Reference: PLANNING APPLICATION NO P/49/18/HH

Proposed erection of two storey infill extension to front elevation and 1st floor infill extension to rear elevation of 39 Conway Drive, Pagham, PO21 4XD by Mr M Hanley.

GROUND FLOOR PLAN PROPOSED 1:50

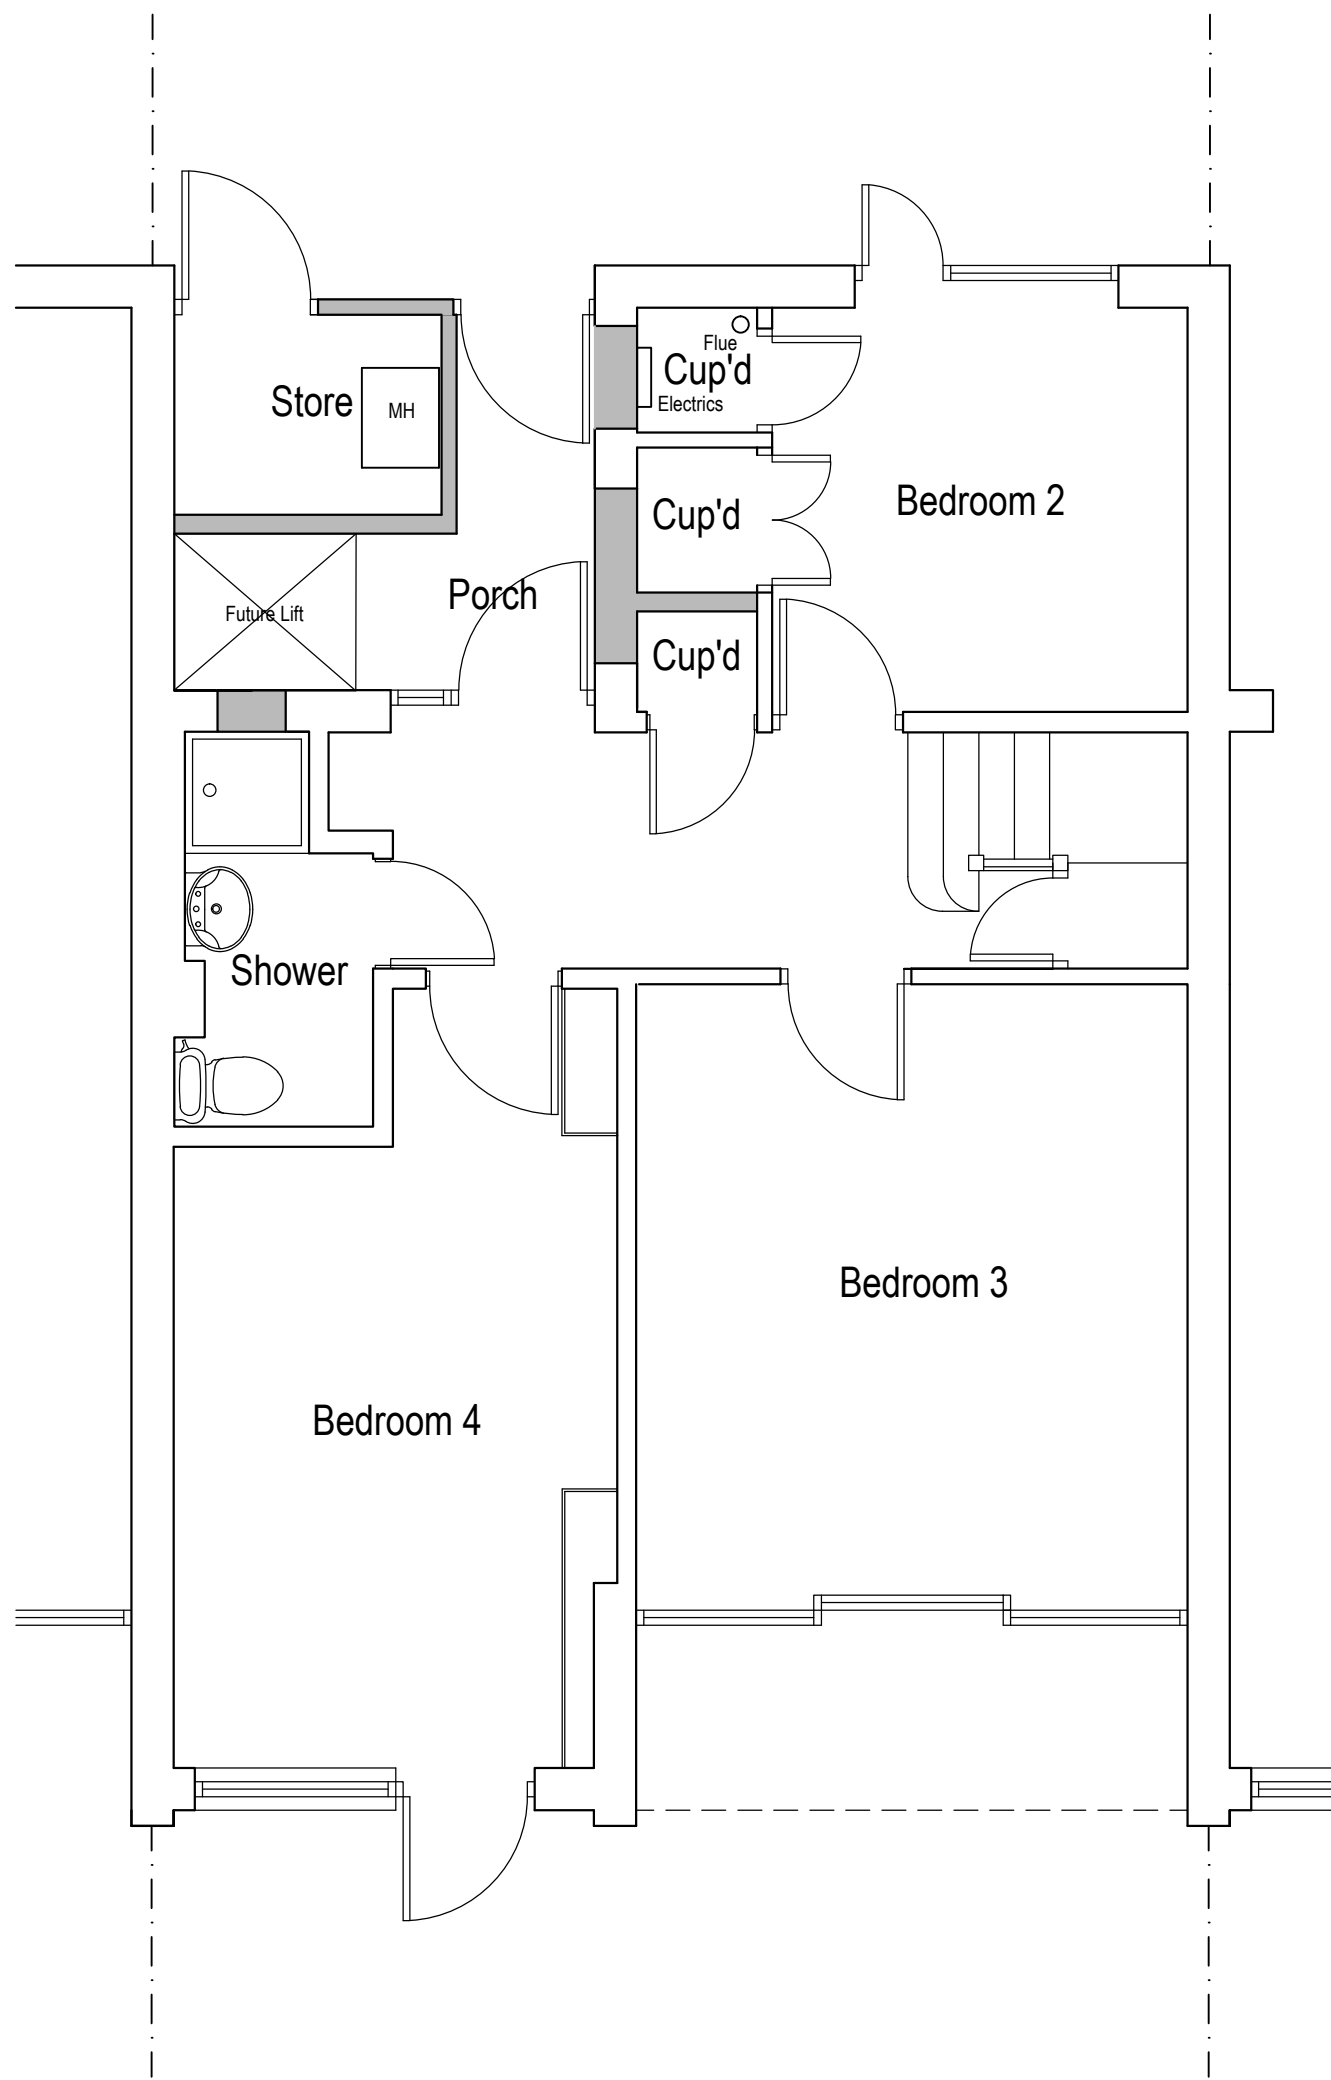
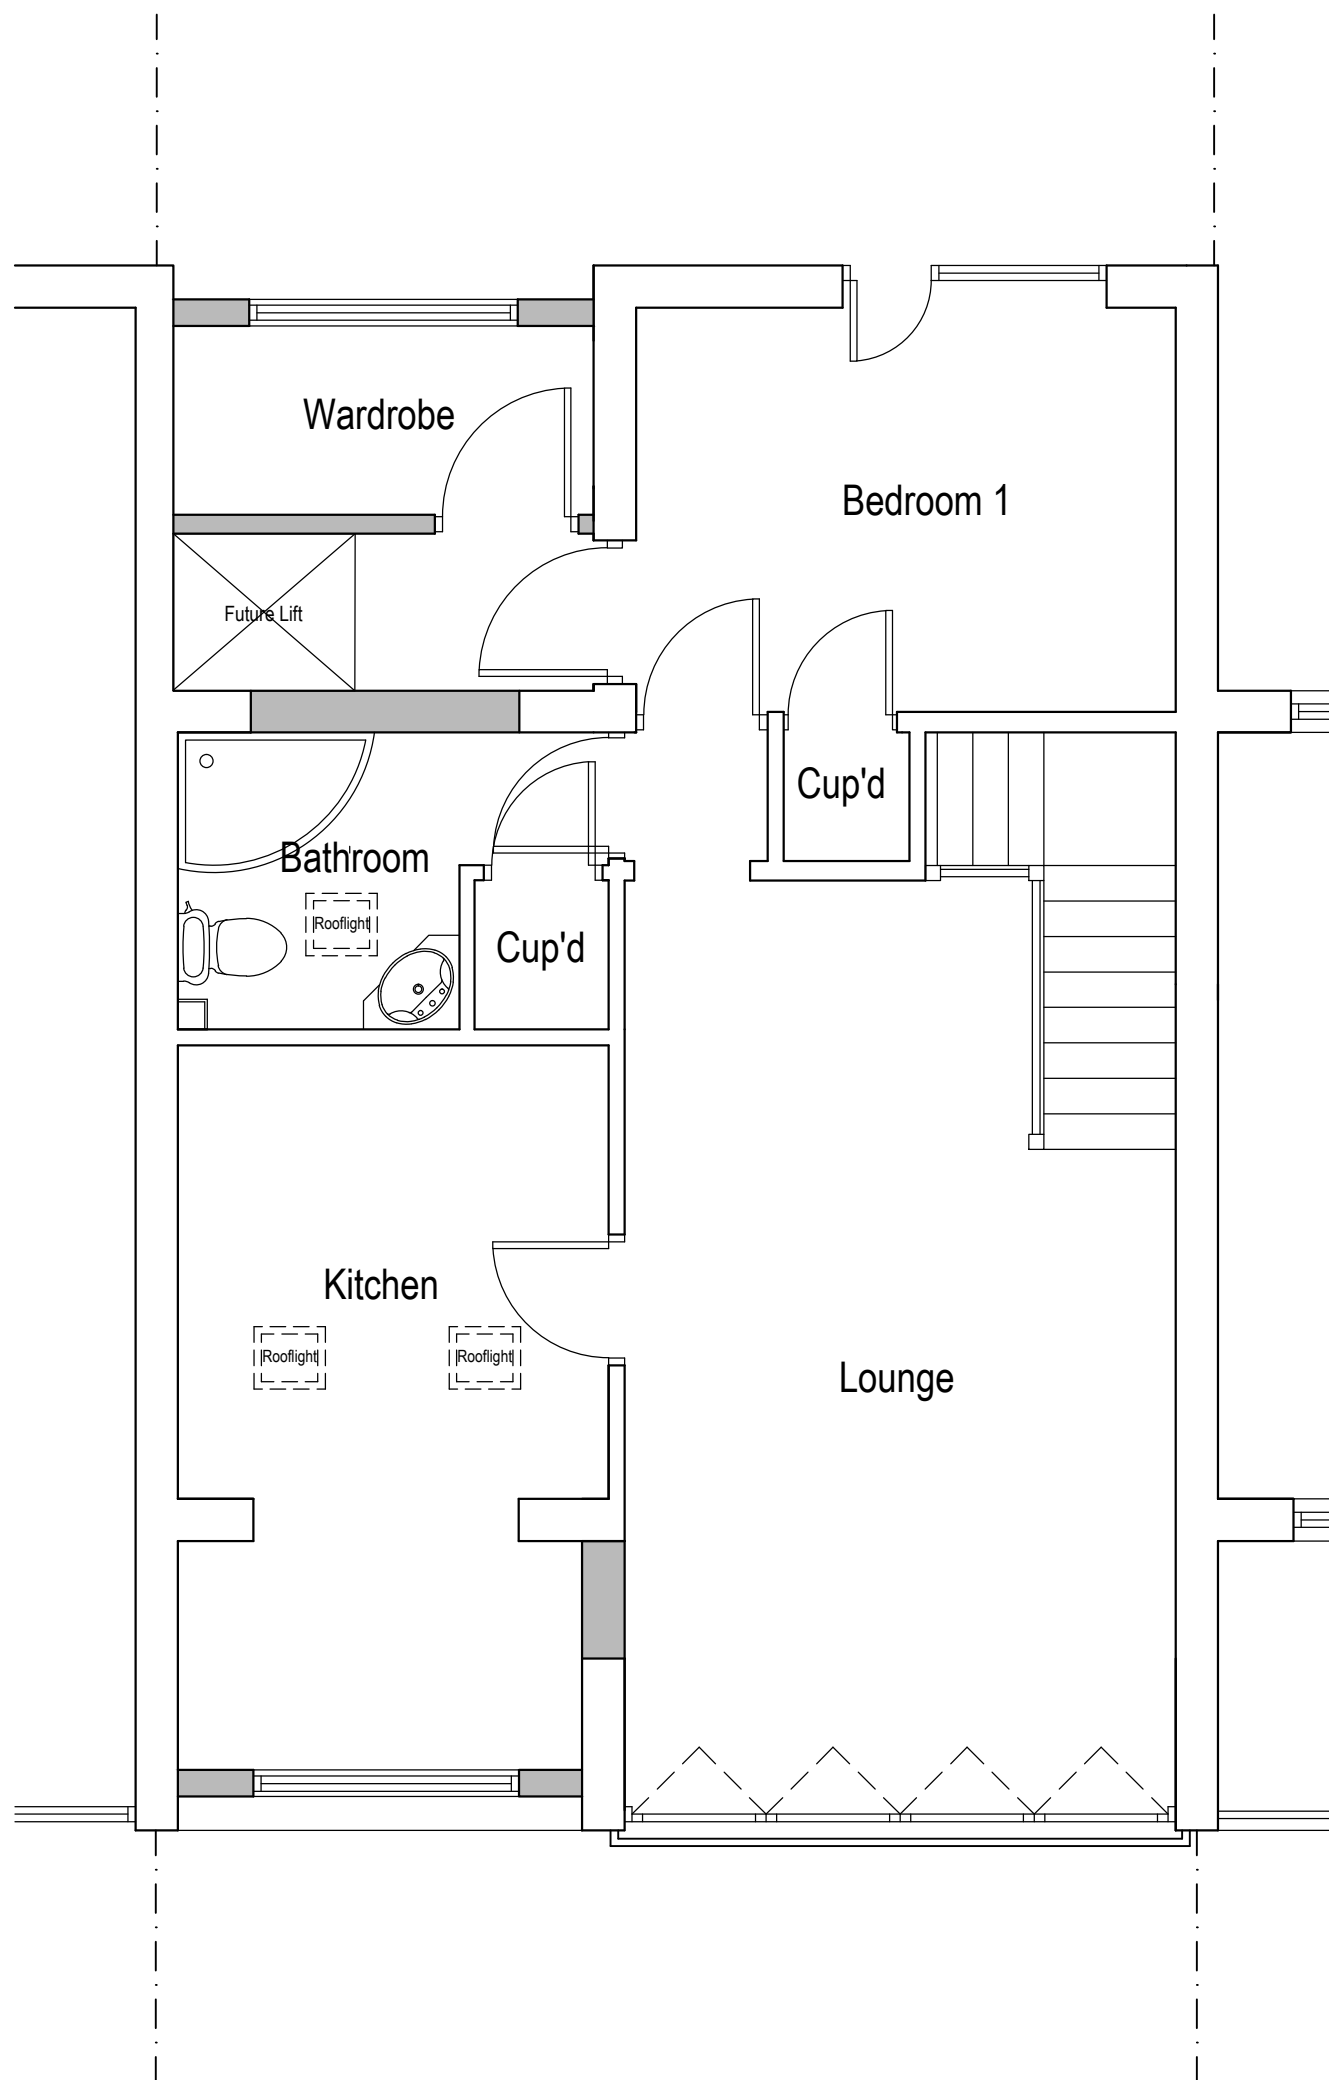
Conway Drive has currently two types of housing, single storey bungalows and two storey three bedroomed part terraced type houses. The house in question is sited within a row of nine of these two storey houses, four of which are identical in style built with yellow bricks to exterior, house number 39 is sited in the middle of these four. Infilling will ruin the character and have an adverse visual impact on this row of houses. When we moved into our house in 2014 our attention was drawn to the deeds where it clearly stated that there should be no boundary fences or walls erected as it would ruin the open appearance of the street. We would suggest that changing the appearance of number 39, and as a consequence house number 41, would totally change the look of the street and may also kick start a cascade effect and other street occupants may follow suit. All of the four houses, numbers 35-41, and indeed the other five red bricked versions numbers 25-33, have front rooms to both the ground and first floor elevations that are currently not connected to another property. As these houses are constructed internally using breeze blocks instead of bricks they are not well soundproofed and the two front facing rooms do give a little respite from neighbour noise audible in other areas of the property. And surely the proposed construction would

impact negatively on the market value of house number 41 as it will become totally terraced and not part terraced as in its current state.

REAR ELEVATION PROPOSED 1:100

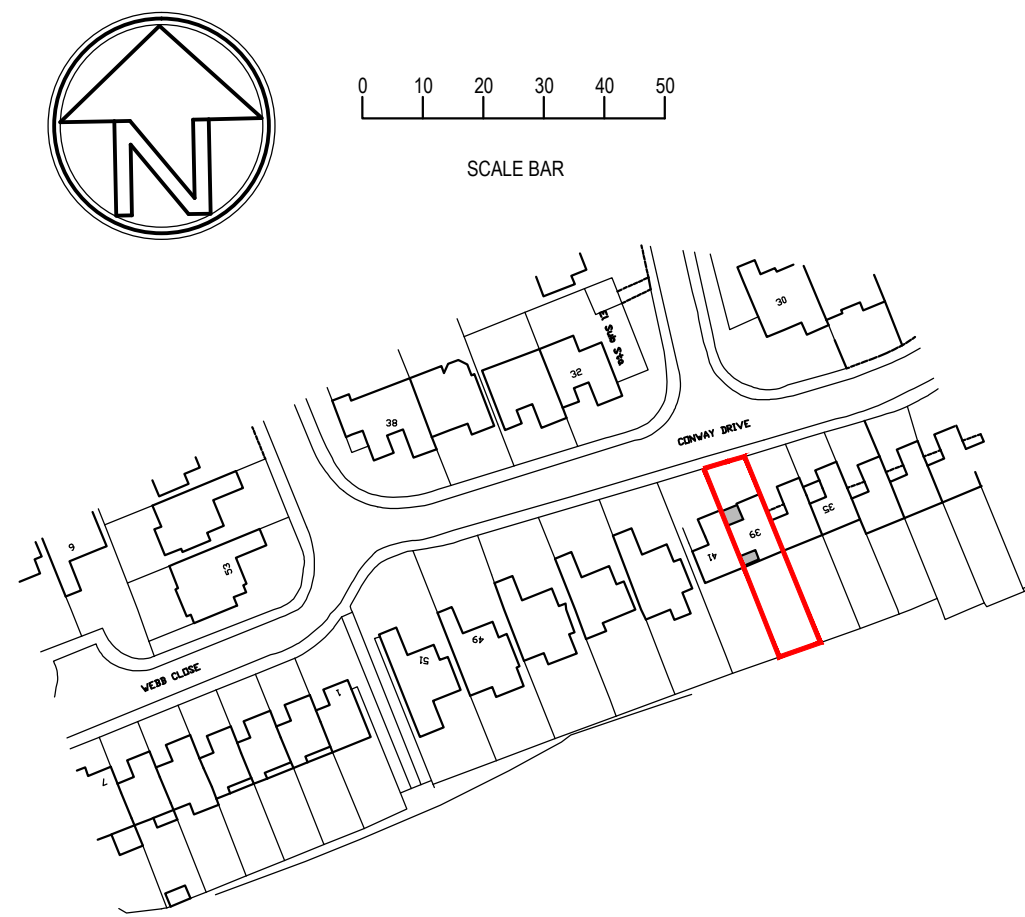
Similarly the proposed first floor infill extension to the rear of the property will change the appearance of the said houses. One other house in the row of nine has indeed closed in the current balcony area but its use is retained as a conservatory type area and not a living area ie; kitchen. This again will impact on number 41 and if approved could encourage other property owners to do the same thereby completely changing the appearance of these currently unique properties.
